14 February 2023

TfNSW Reference: SYD20/1175/07
DPE Reference: SSD-9978934

**RESPONSE TO SUBMISSION
STAGE TWO COCKLE BAY WHARF REDEVELOPMENT (SSD-9978934)
249 WHEAT ROAD, COCKLE BAY**

B	ISSUE B	NT 29/09/21	
A	ISSUE	NT 08/09/21	
REV	DESCRIPTION: PRELIMINARY PLAN	DRAWN	INITIAL/DATE

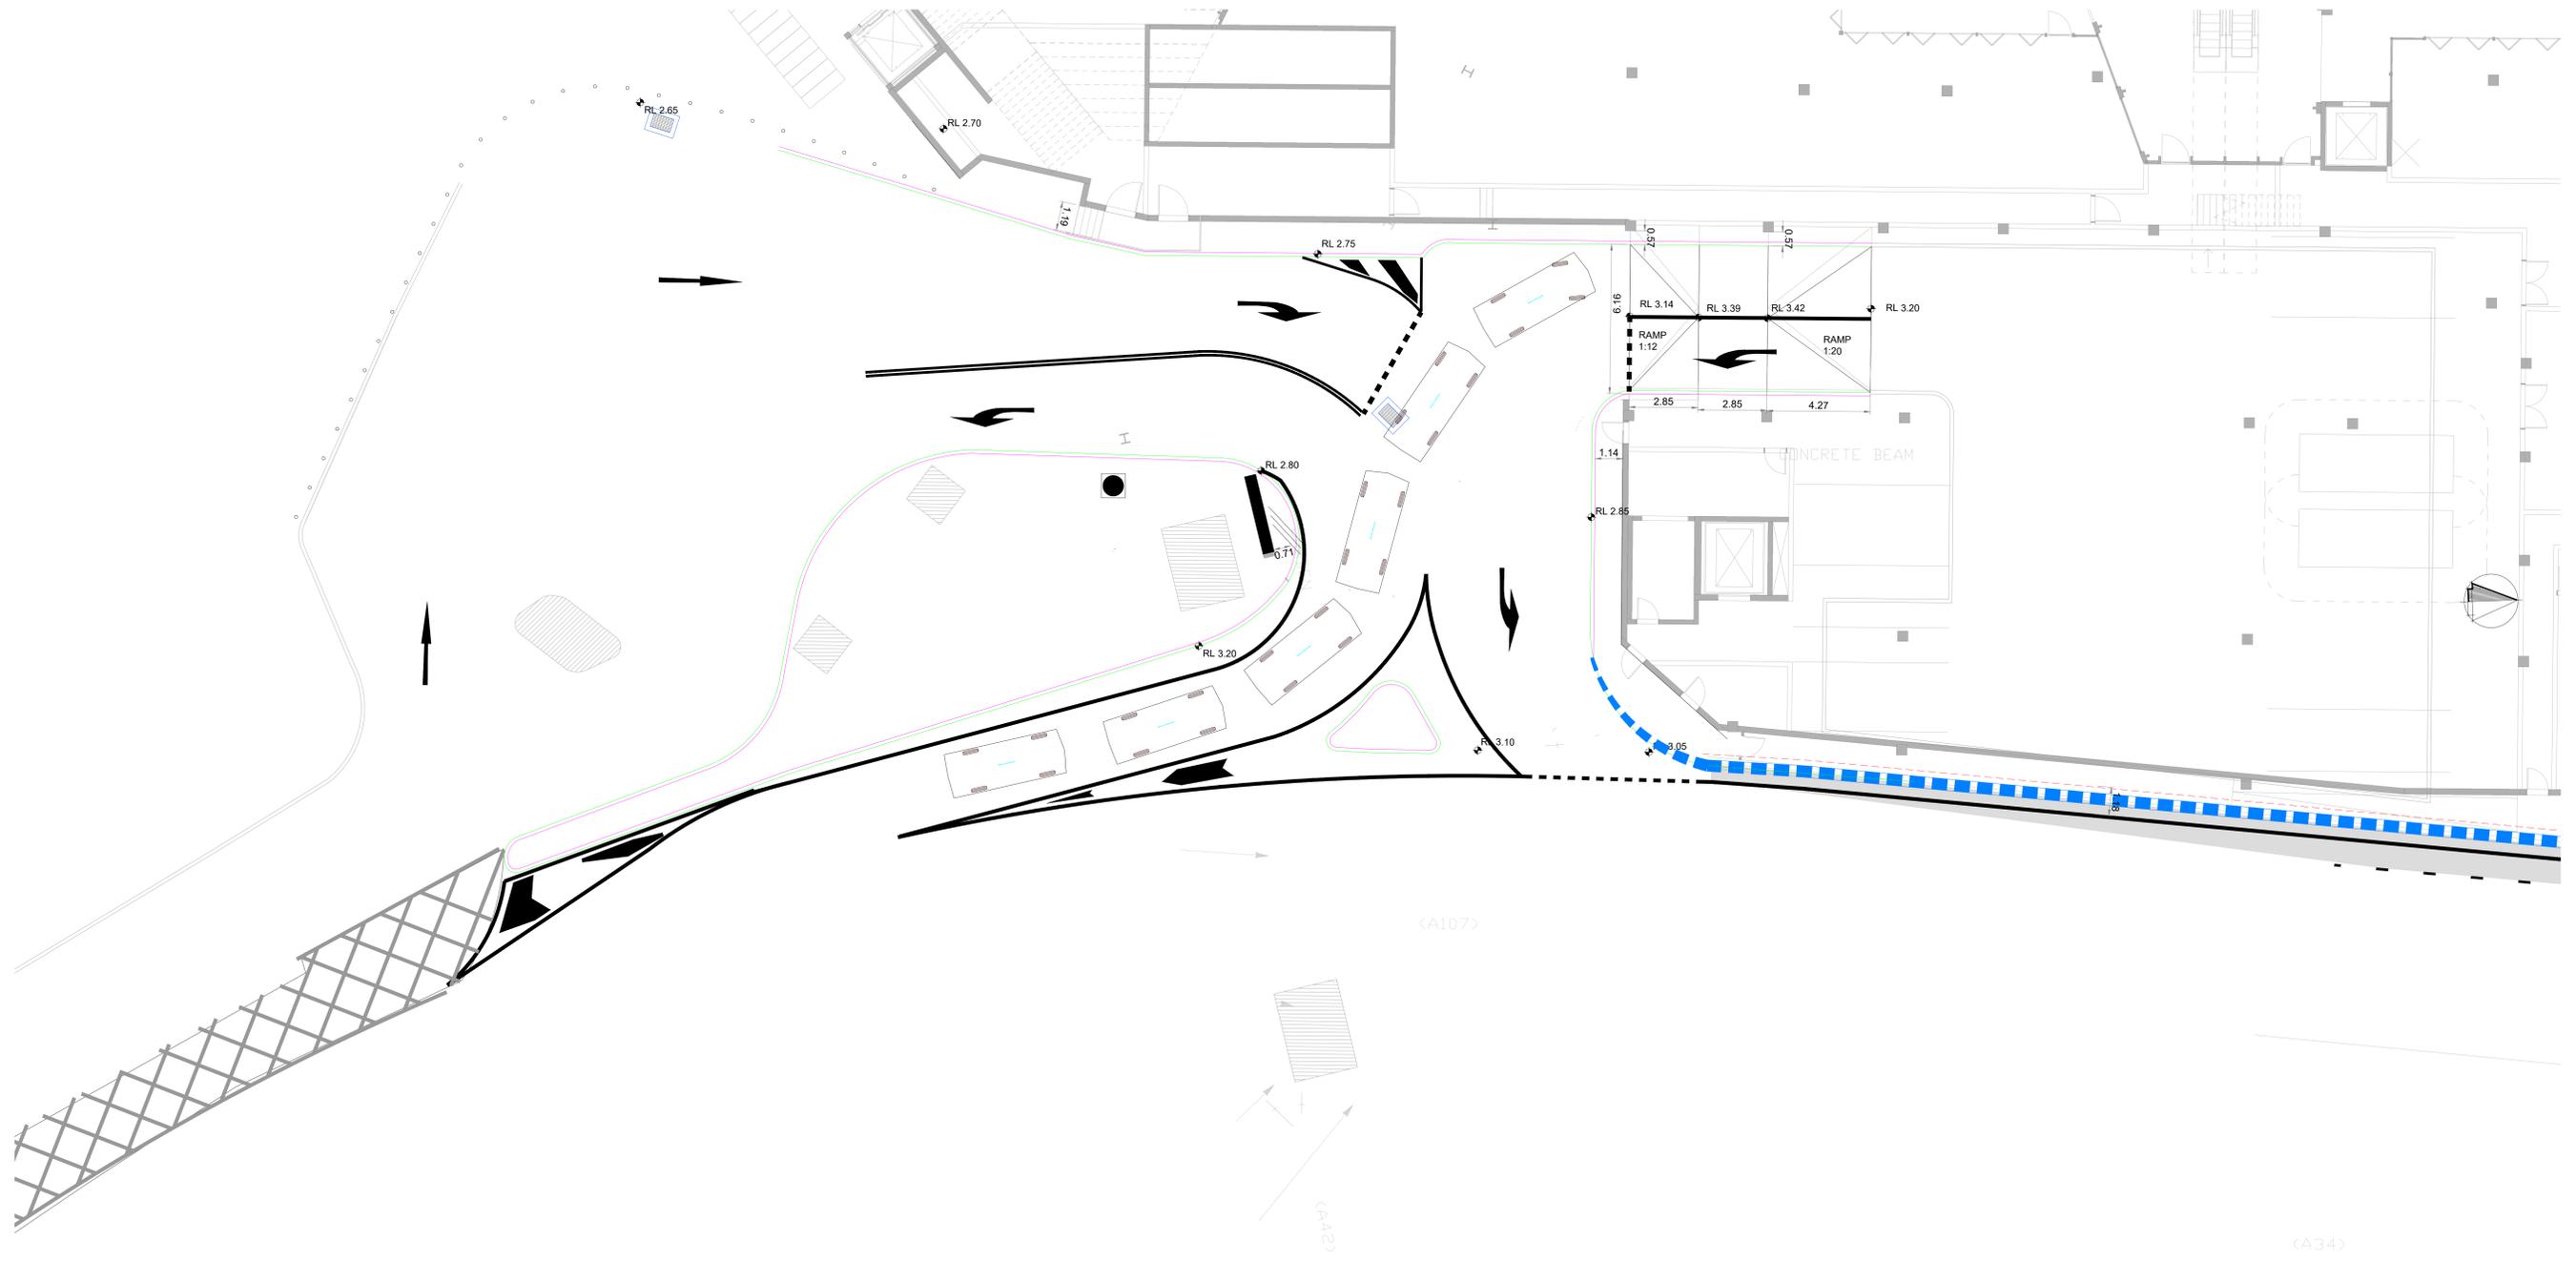
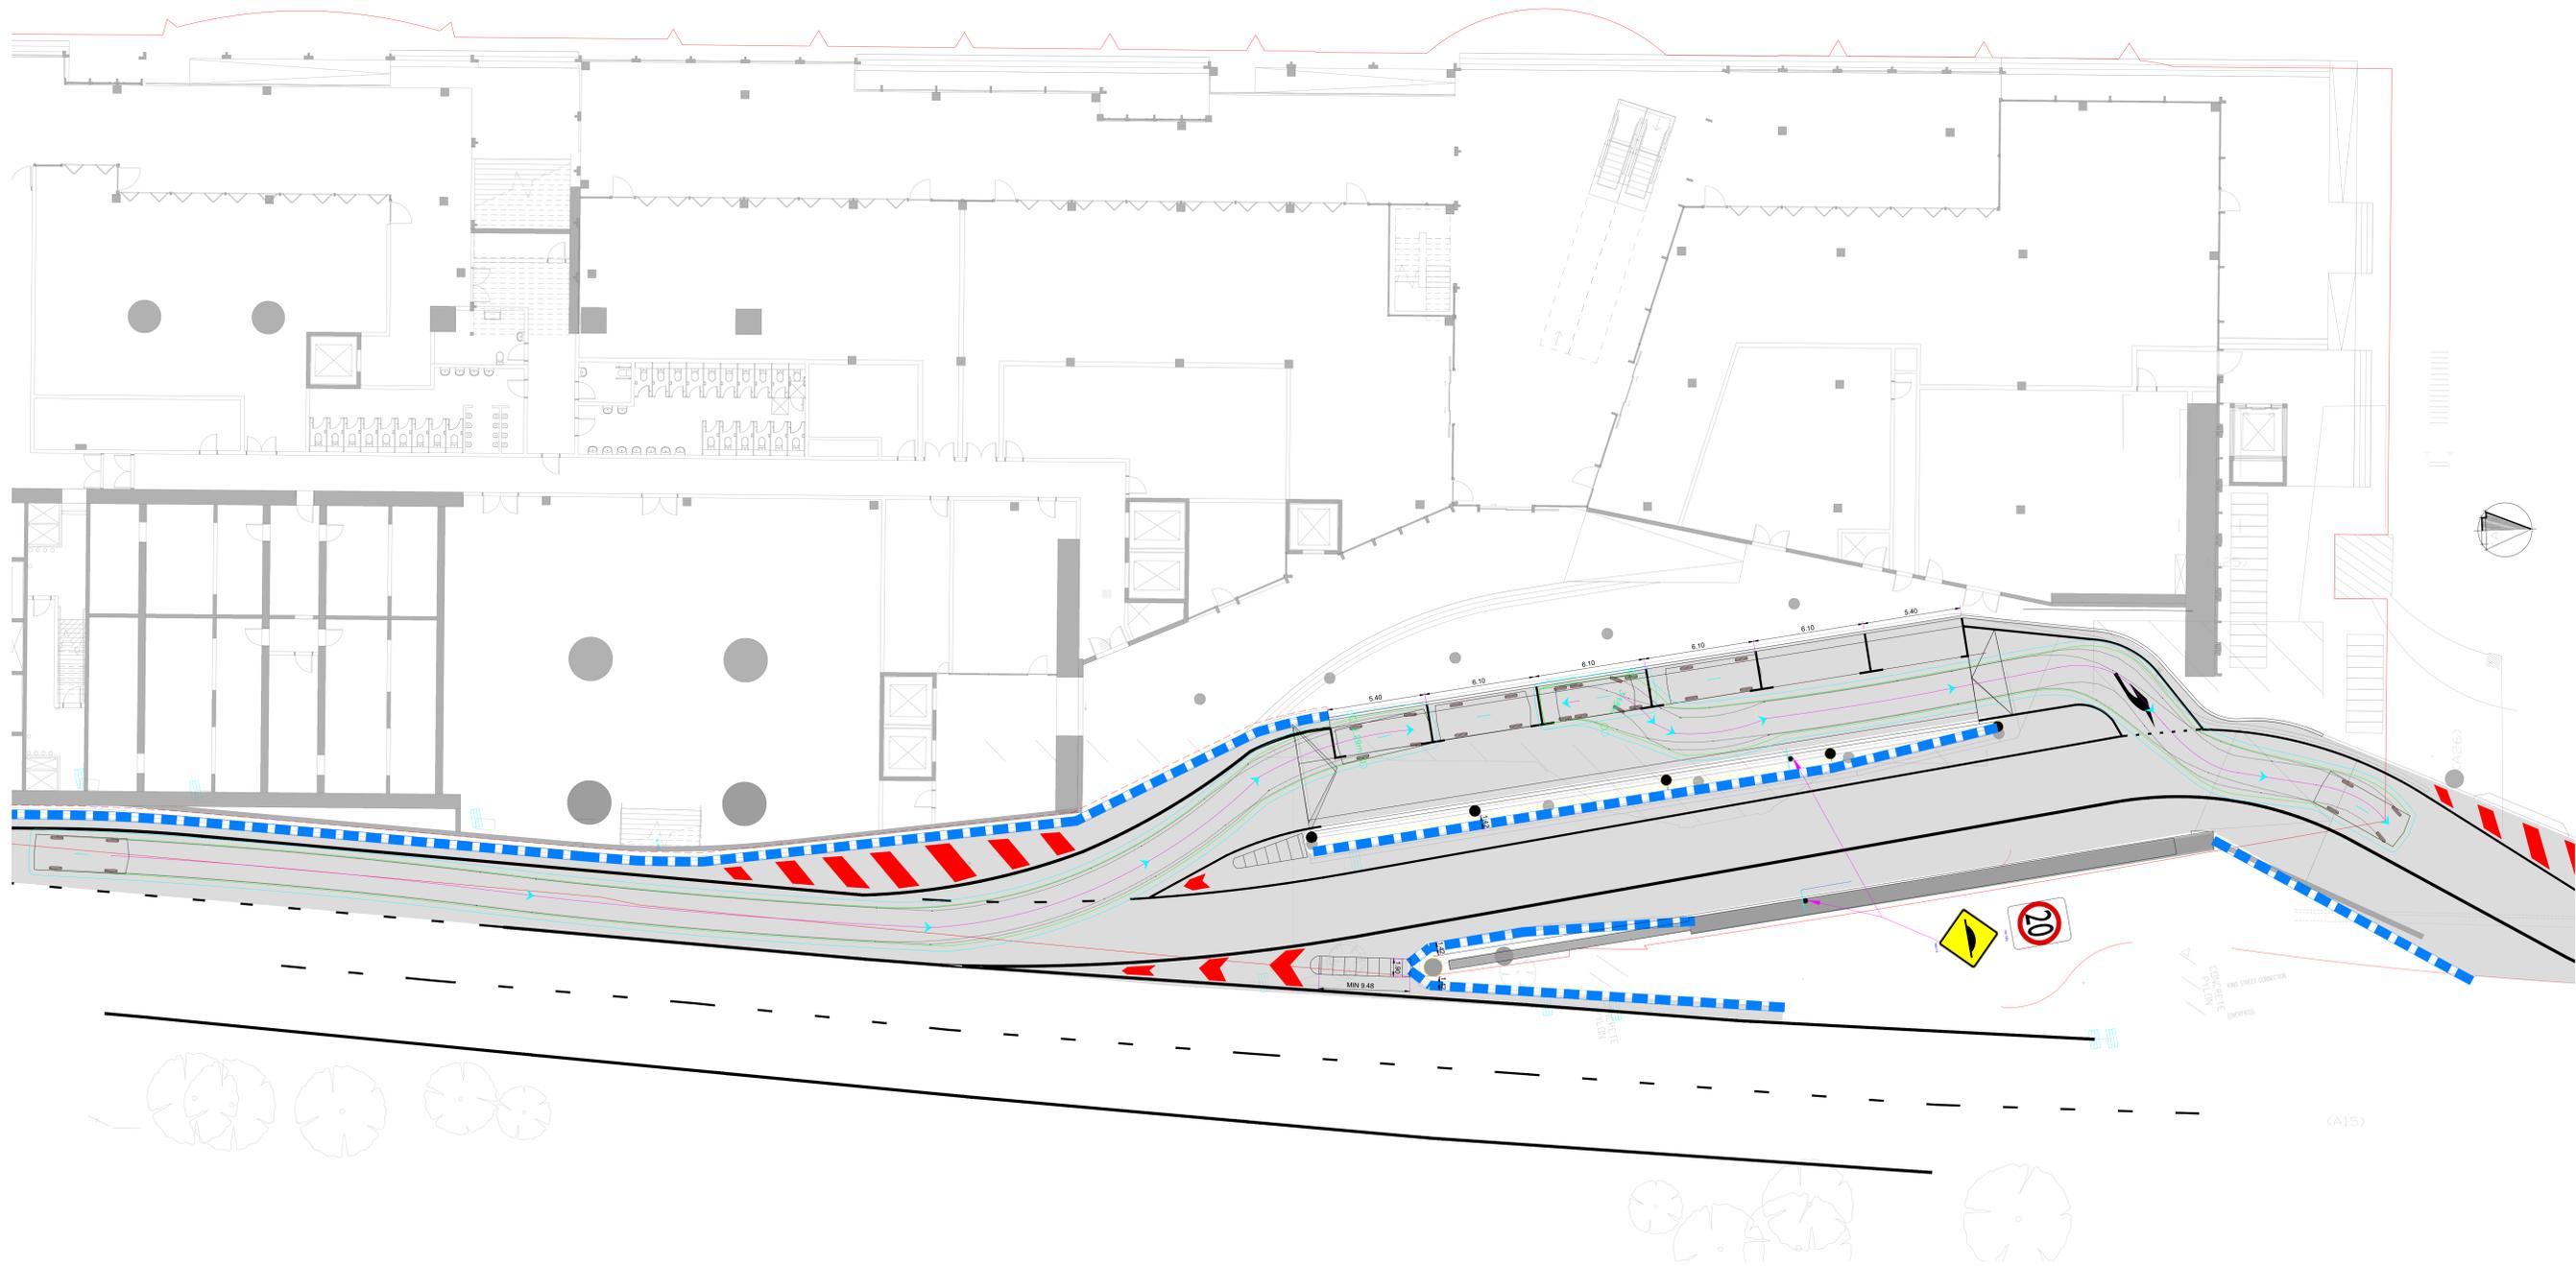
- Sight distance assessment should be based on a formalised Safe Intersection Sight Distance (SISD) checks and demonstrated in the vertical plane as well as horizontal plane. The vertical plane is particularly important due to the proposed F Type barrier.
- Appendix W – Swept Path analysis indicates HRV as the largest vehicle. However, 14.4m buses will be entering and exiting the internal service road. Swept path analysis should be updated showing the 14.4m bus traversing through the internal service driveway and egress driveway on Harbour Street.
- Concern is raised with delays and queuing from vehicles exiting the egress driveway on Harbour Street which may block access to the loading dock. This is a particular concern for:
 - MRV vehicles and Buses due to the swept path constraints at the Harbour Street intersection and access is unrestricted during peak periods.

- An assessment of the forecast demand for the porte-cochere was undertaken for the AM peak only. The demand in the PM will be generated by both the commercial and retail land uses.
- In addition, justification for the development not generating or attracting private buses or coaches has been provided. It is considered likely the retail and public domain land uses will generate some private bus or coach trips.
- Queuing assessment of the porte-cochere has been undertaken however, there could be instances where queue will overflow. This needs to be reviewed to identify measures that would ensure road safety and operational issues do not occur on Wheat Road.

- Swept path analysis should be updated to include 14.4m bus accessing the internal service road and Harbour Street access points. Designs of the internal service road and access driveways should be updated accordingly.

- Location of vehicle stopping/parking area for valet parking vehicles, taxi and pick and drop off facilities.
 - Details of the types and frequency of vehicles accessing the porte-cochere and updated swept path analysis based on the largest vehicles.
